# SOLACE OF COLORADO SPRINGS

## PRELIMINARY PLAN

SP-20-001

# Prelim Plan\_V2.pdf Markup Summary

### PRELIMINARY UTILITY PLAN

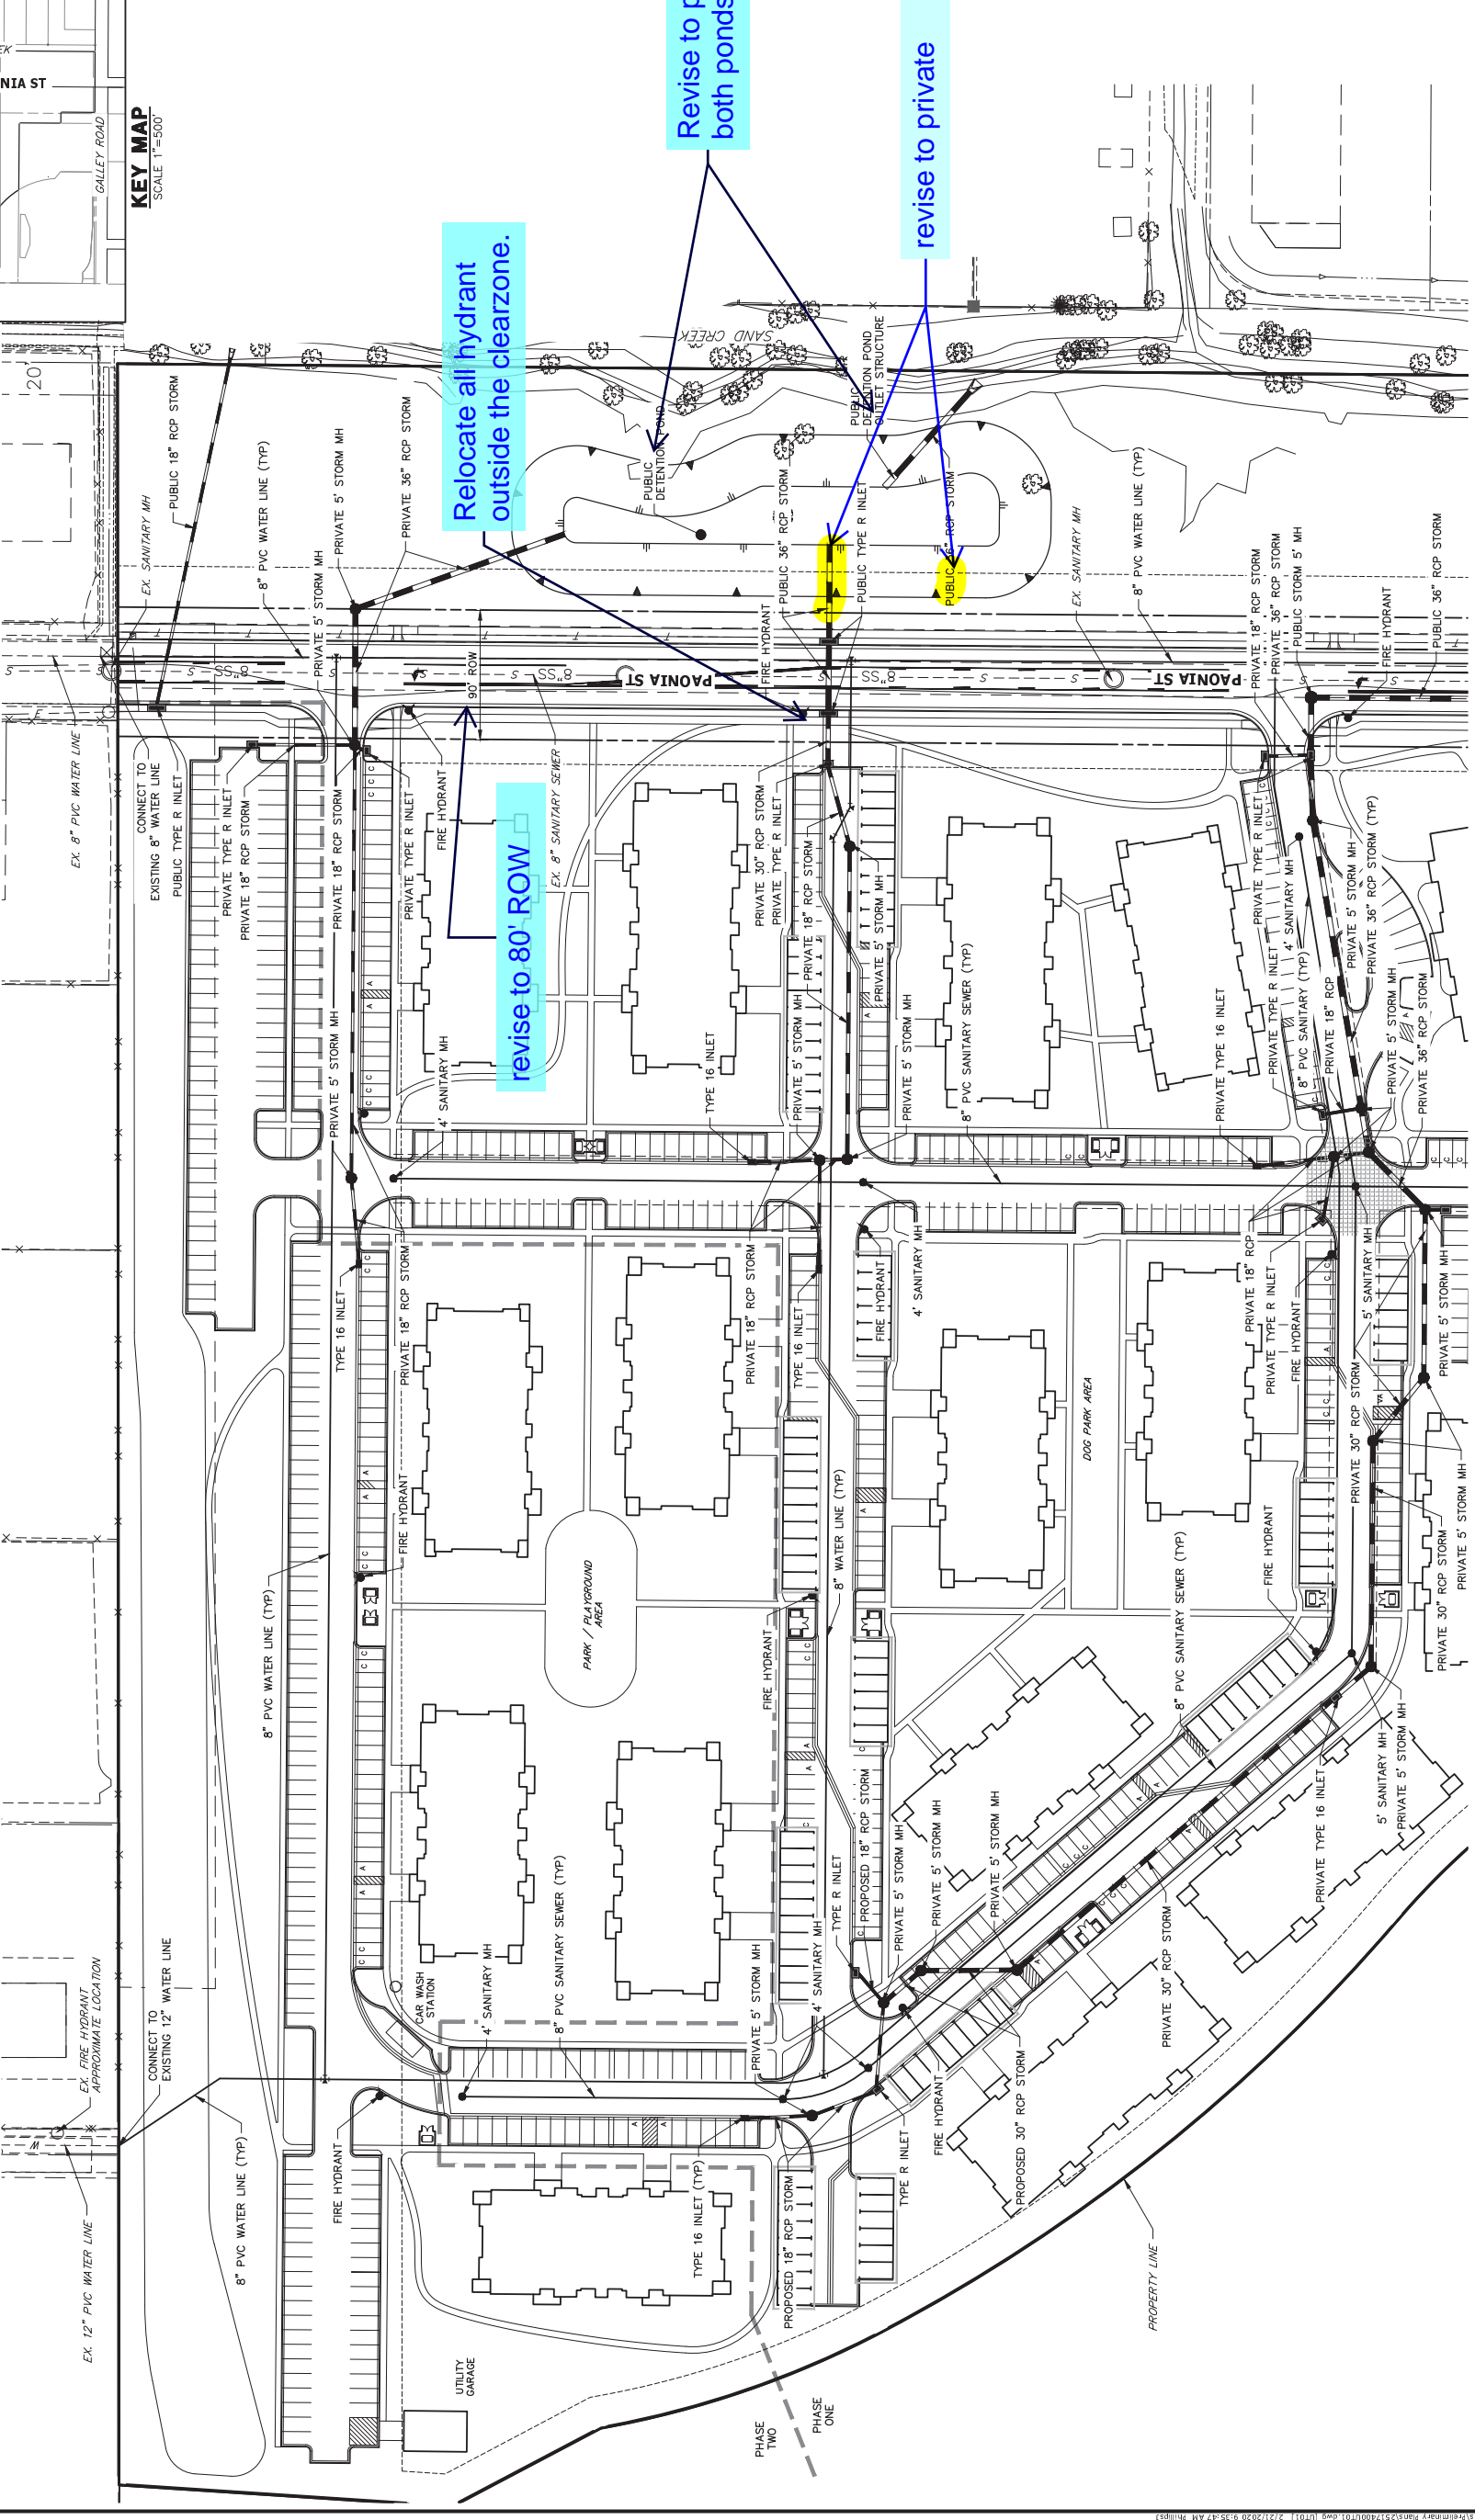
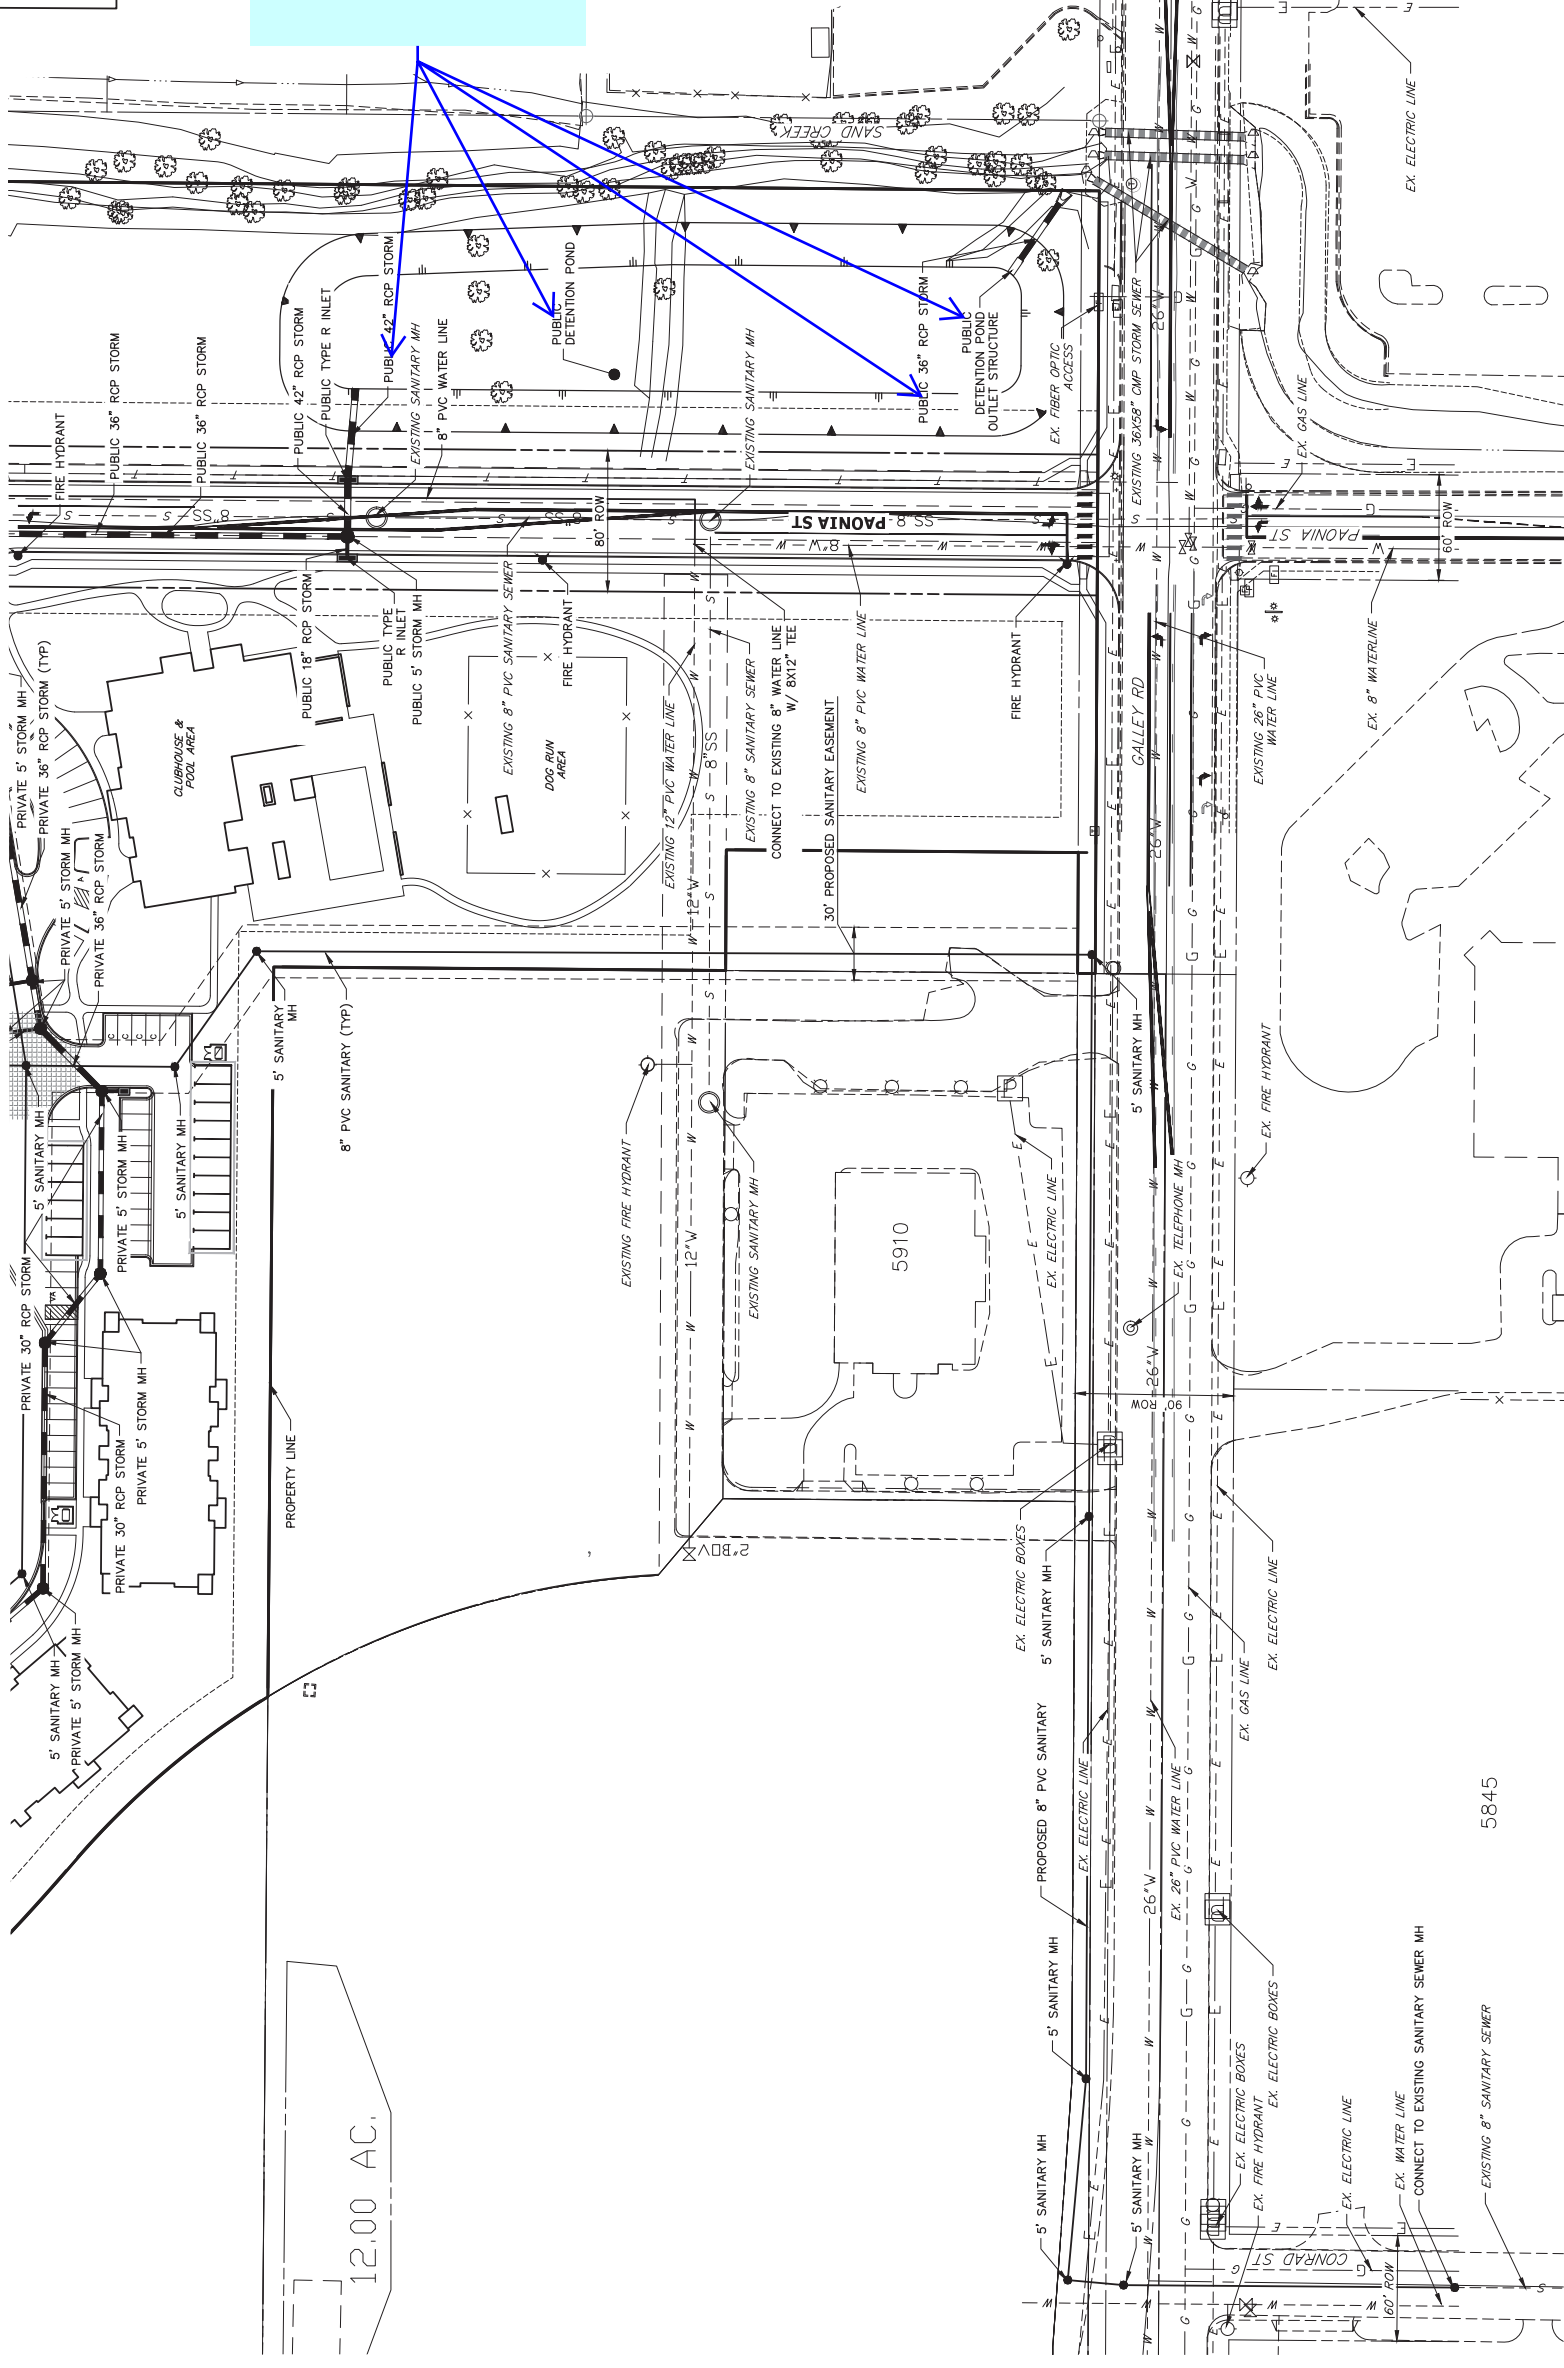
In was noted in your response that the hydrants have been located 12' off the edge of the travel lane. The clear zone is 14' for non-residential collector roadways therefore the hydrant would still be in the clear zone. Please be sure to locate all fire hydrants outside of the clear zone. A note may also be added that the fire hydrants should be located outside the clear zone
